**WELWYN HATFIELD BOROUGH COUNCIL – DEVELOPMENT MANAGEMENT**  
**DELEGATED REPORT**

**APPLICATION No:** N6/2013/2092/AD

**SITE ADDRESS:** 53 Howardsgate, Welwyn Garden City

**DESCRIPTION OF DEVELOPMENT:** Installation of fascia sign, projecting sign and window vinyls.

PROPOSED SHOPFRONT/SIGNAGE

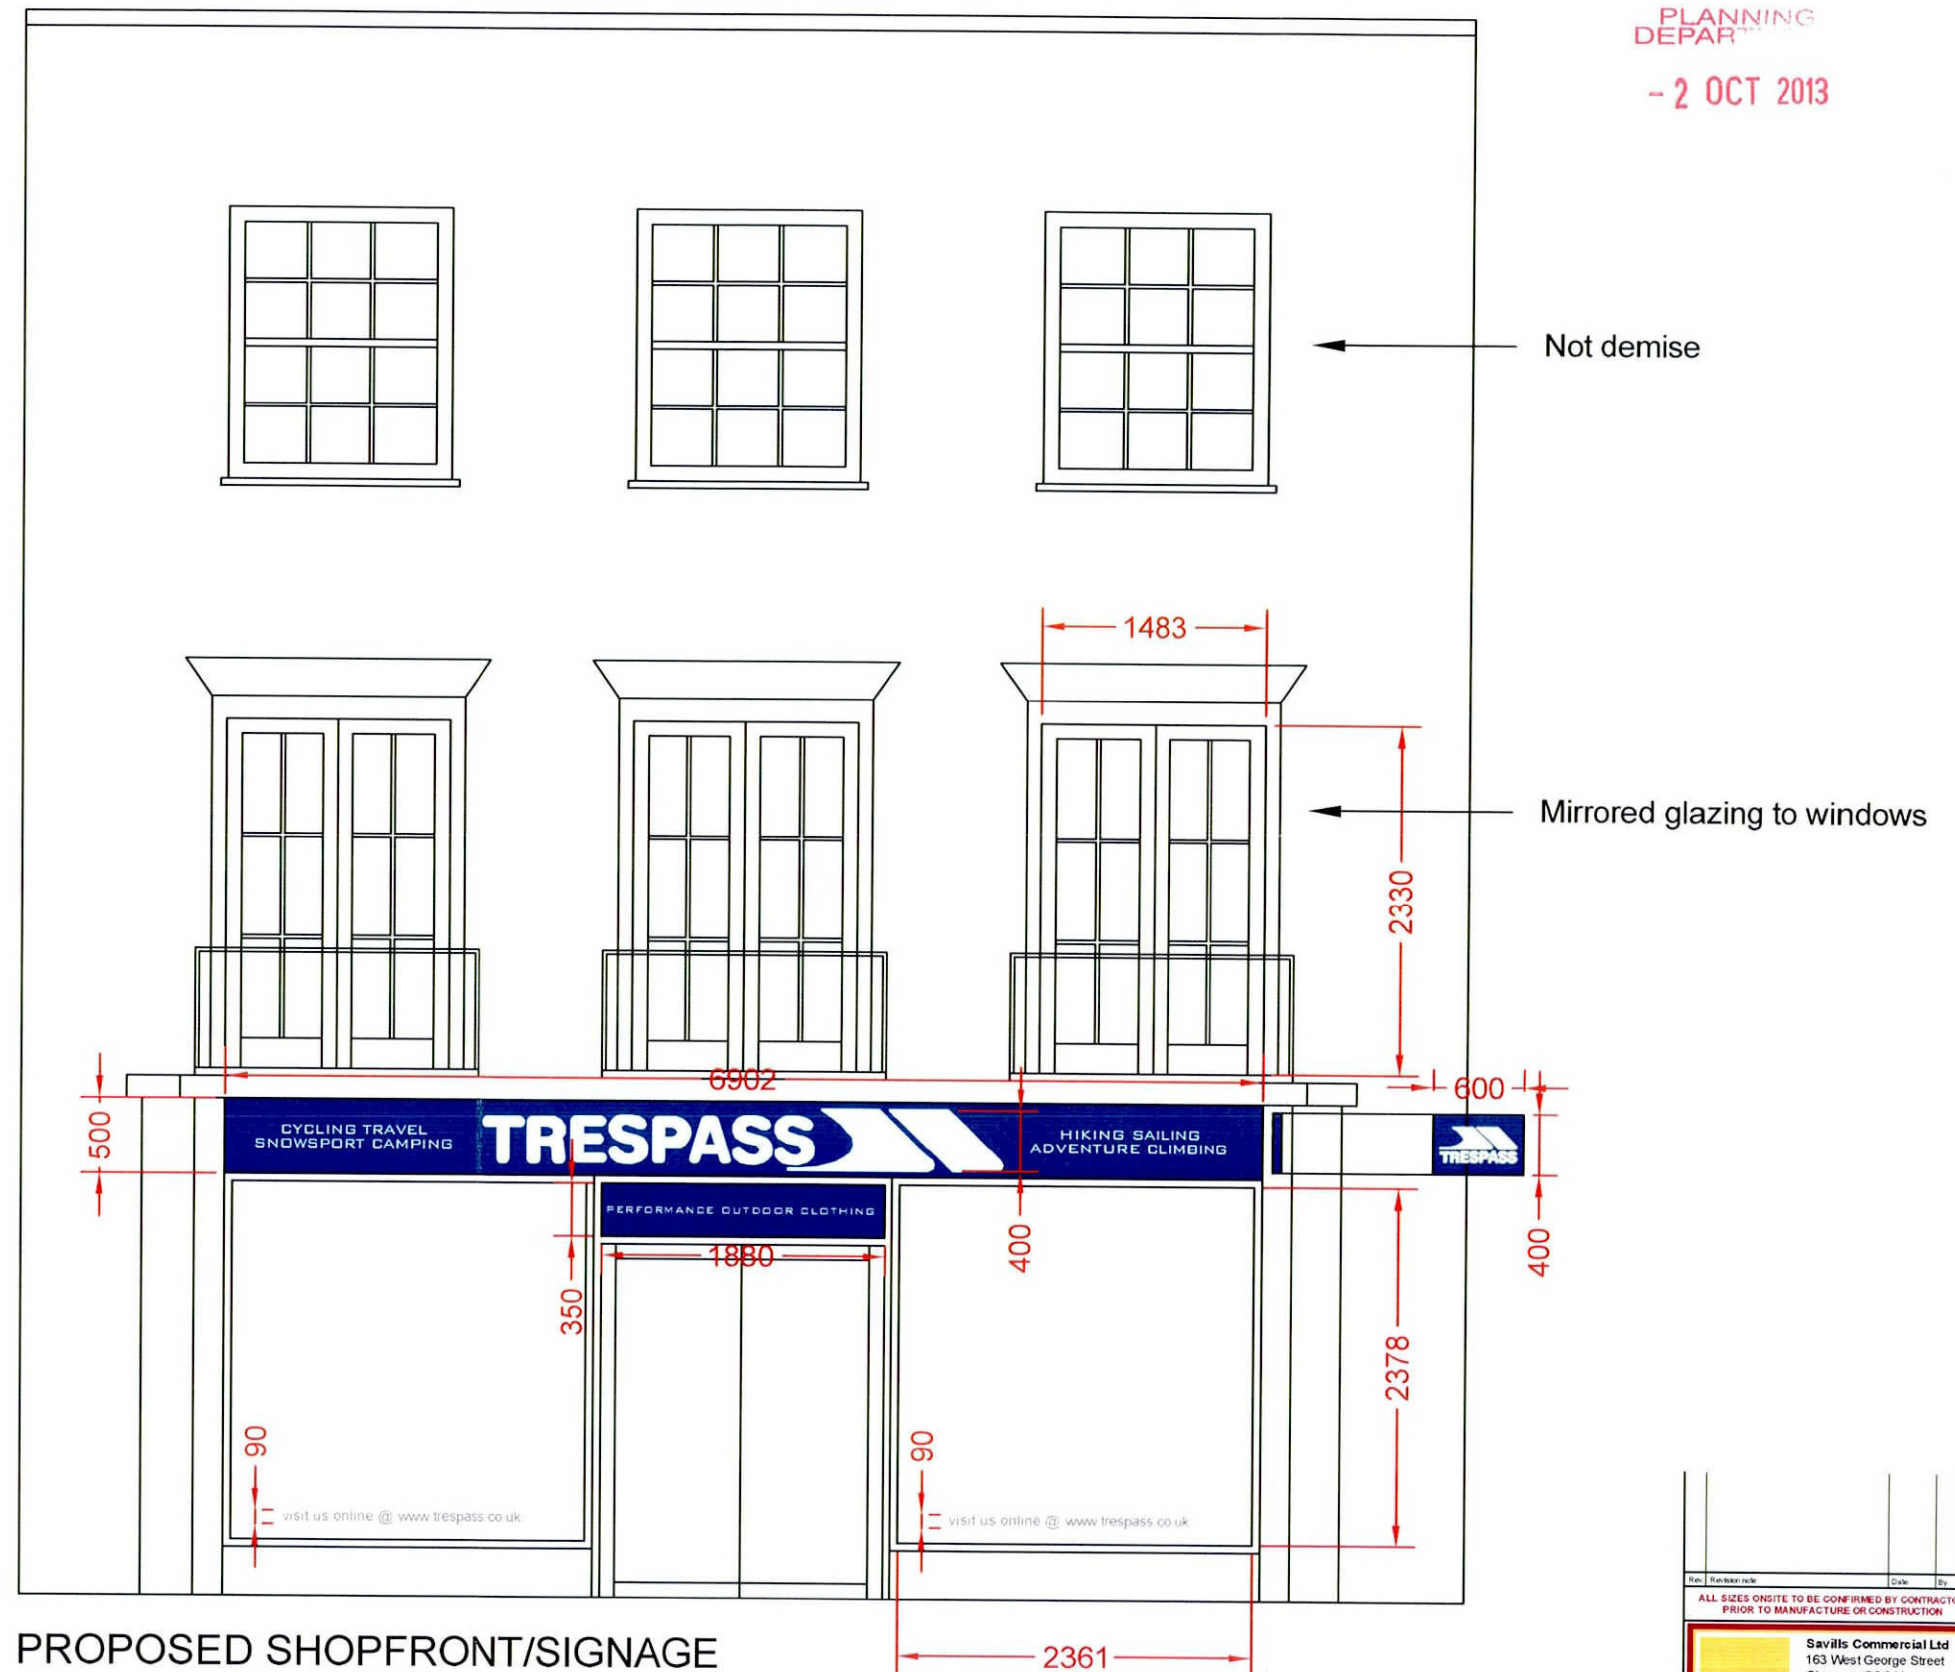
As shown on the submitted plans, the application proposes a blue painted background to the fascia with the remaining surrounds (pilaster, entablature and others) remaining white. It would feature white text, primarily in the form of a word and corporate logo taking up approximately half of fascia width together. Further to this coverage, white text of about half the fascia height would occupy the majority width of either space to the left and right.

Paragraph 6.9 of the SDG features specific design criteria for proposals on this type of designed entablature shopfront in order to secure the high quality design expected by policy D1 of the District Plan. These include the use of (i) individual lettering fixed directly to the white painted fascia, as the preferred form of advertisement. Therefore the use of acrylic lettering on the existing unauthorised signage or on the proposed fascia signage, and its siting on a blue painted fascia, would not comply with this element of criterion (i). Some nearby units of the same designed entablature shopfront design have colored fascias to a similar or greater degree than proposed, such as Specsavers adjacent to the north. However some may have been permitted prior to the 2005 District Plan adoption, such as Specsavers adjacent which was permitted in 2003. On the other side adjacent to the south, the Shoe Zone shopfront recently permitted broadly accords with the design criteria of the SDG. Furthermore, in 2012 the Council produced its guide to shopfront and advertisement design which reiterates this requirement, adding weight to the need for proposals to adhere to the guidelines set out in the SDG.

Further to the above, two other design criteria outlined in para 6.9 for designed entablature shopfronts, (ii) and (iv), are also relevant. IV has similar requirements to above. It states that a box sign with a coloured background which is less than  $1/3^{\text{rd}}$  of the length of the fascia, centrally positioned to show a white background on either side, will also be acceptable. This proposal does not propose a box sign however and therefore the blue colouring across the length of the fascia would not accord with this criterion. The signage would not however exceed the fascia depth and therefore the proposal accords with criterion (ii). However on balance, given that the design of the signage fails to accord with criteria (i) and particularly (iv), the proposal would result in a design which visually dominates the shopfront and surrounding element of street scene. In doing so, it would also fail to accord with the aims of criteria (i) and

The fascia signage includes a corporate logo. Paragraph 6.6 of the SDG states that the overriding aim of preserving and enhancing the uniqueness of the area is more important than the promotion of corporate images. Adjacent shopfronts have proportionately designed corporate logos, as did the previously approved frontage. In this instance the design/size of the company logo (graphic and main text element) clearly exceeds the 1/3<sup>rd</sup> fascia length sought in the SDG guidance. It is acknowledged that the guidance refers to signage/logos within box signs unlike the proposed signage which sits directly onto/along the fascia. However in whichever form the signage takes, the purpose of this 1/3<sup>rd</sup> fascia length limit for corporate logos is to ensure that advertisements sit subservient to the fascia, shopfront, host building and wider street scene in order to protect the visual amenities of the area. The proposed corporate logo would be disproportionate to the fascia and shopfront dimensions. Accordingly it would detract from the character of the shopfront and its host building, and thus the surrounding street scene of Howardsgate in this conservation area. This element of the proposal therefore fails to accord with the aims of paragraph 6.6, parts (i) and (v) of paragraph 6.5 and part (i) of paragraph 6.8 of the SDG, as expanded upon earlier in this report. In doing so, this aspect of the proposal fails to represent high quality design and fails to respect and relate to its surroundings as required by policies D1 and D2 of the District Plan respectively, and the broadly consistent design aspirations of the NPPF.

However the proposed fascia signage, by virtue of the scale/dimensions of the fascia signage and its design, particularly its extent of logo/text and colour coverage, would appear overly prominent and disproportionate to the fascia and wider shopfront when viewed from the surrounding area of the street scene of Howardsgate. In doing so, it would fail to represent high quality design as it would not respect the visual amenities and thus character of the host shopfront, building and street scene of the conservation area, contrary to policies D1 and D2 of the District Plan, the Council's 2005 Supplementary Design Guidance on advertisements and paragraph 67 of the NPPF.

1. The proposal, by virtue of the scale/dimensions of the fascia signage, extent of logo/text coverage, and its design, would fail to represent high quality design and would not respect or maintain the character and visual amenities of the host shopfront, building and the surrounding street scene of Howardsgate in the conservation area. It would therefore fail to satisfy policies D1 and D2 of the District Plan, the Council's 2005 Supplementary Design Guidance on advertisements and the NPPF
